Dinuka McKenzie - M5 Widening

1st June, 2011

M5 West Widening

Figure 8.7 Location of existing and proposed new or augmented noise walls

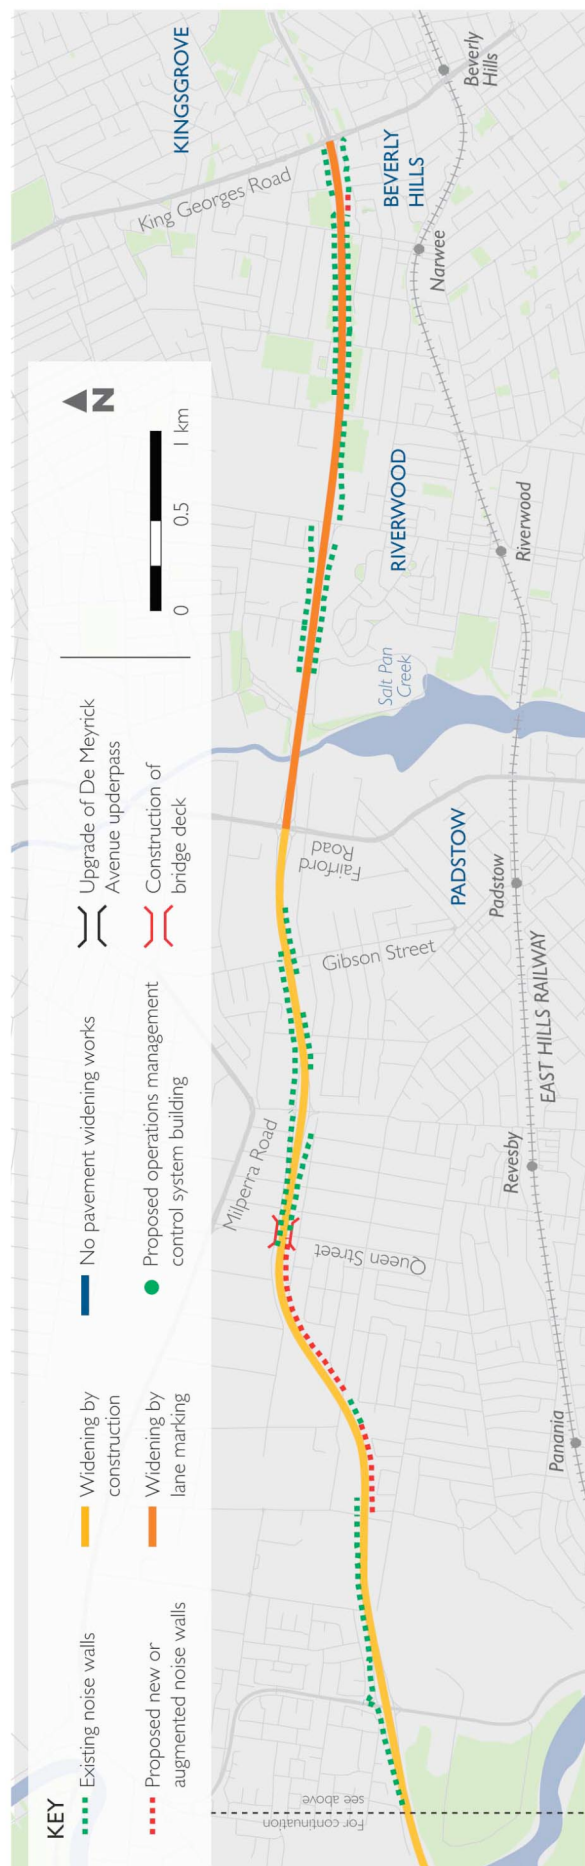
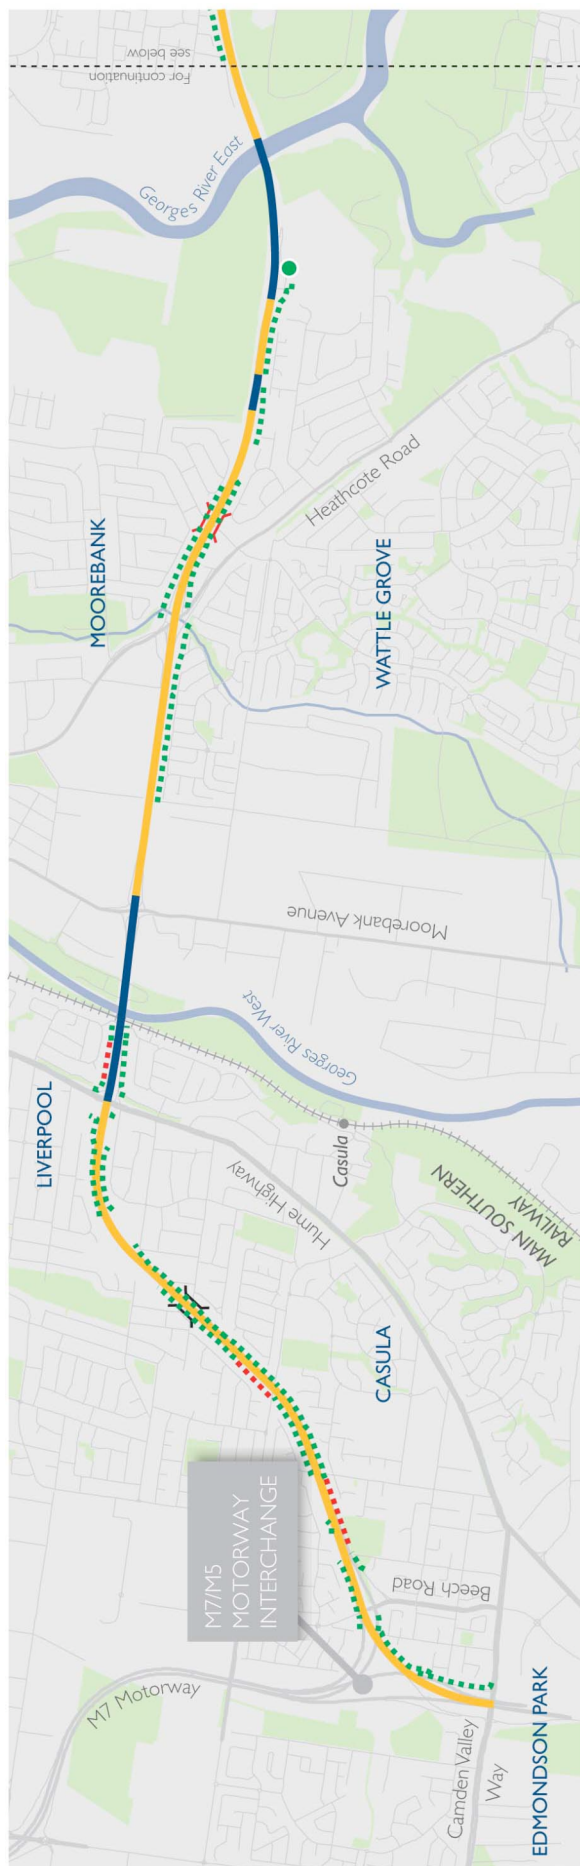
Contrary to the suggestion in the EIS, and without any consultation to the neighbours so affected, the RTA altered their position in terms of barriers in proximity to the Legato property during construction and erected barriers lower than nominated in the EIS.

Yet despite the above acknowledgements no action was taken as to the RTA breaching the conditions of consent for some considerable point in time. The result of the Legatos taking action in relation to compensation for a further resumption of land for the M7 was a concession made to increase the height of the barriers at the subject property with a claim that as a result of the M7 works compliance with the ECRTN criteria would be achieved.

These levels were conducted after the extension to the barriers at the rear of the Legato property and therefore show an increase in noise contrary to that identified in the M7 EIS.
